**Addendum No. 1**

RE: Contract ID C203408

**Scotland County (B-4639)**

Bridge #17 Over Gum Swamp On US-15/401

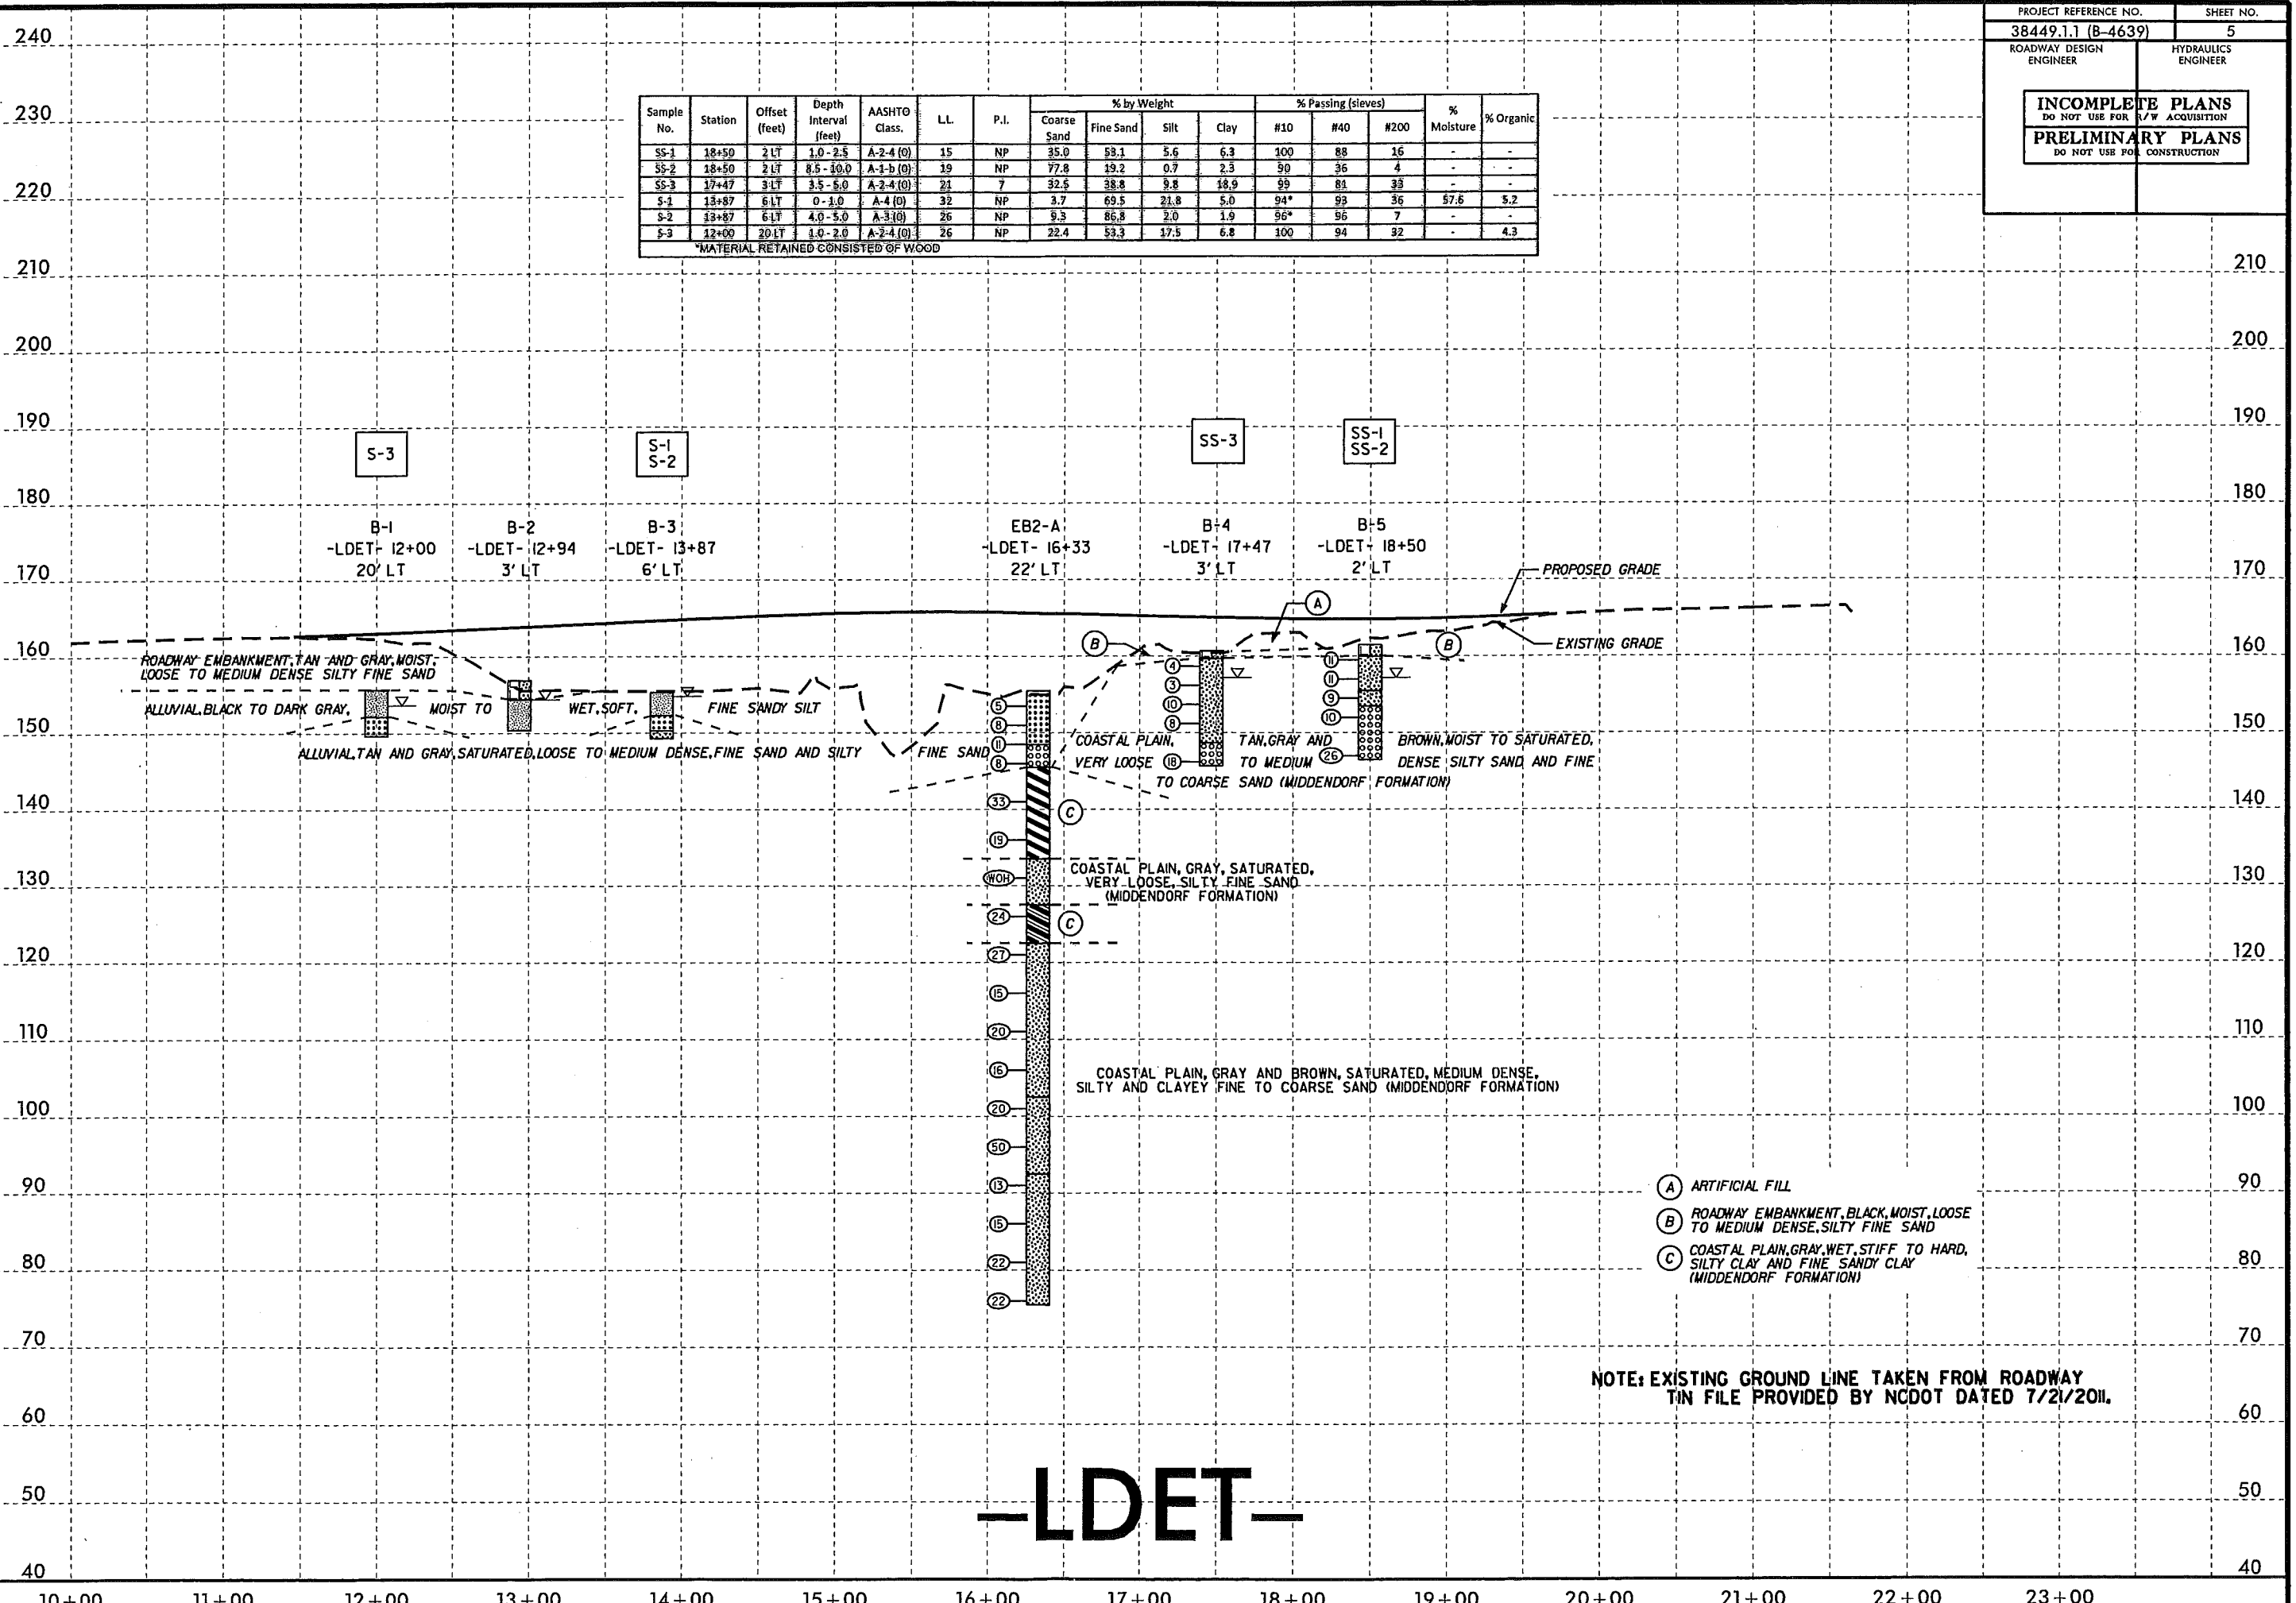
On Sheet No. 3B the earthwork volumes have been revised to account for the use of Select Granular Material in the embankment for the detour. Please void Sheet No. 3B in your plans and staple the revised Sheet No. 3B thereto.
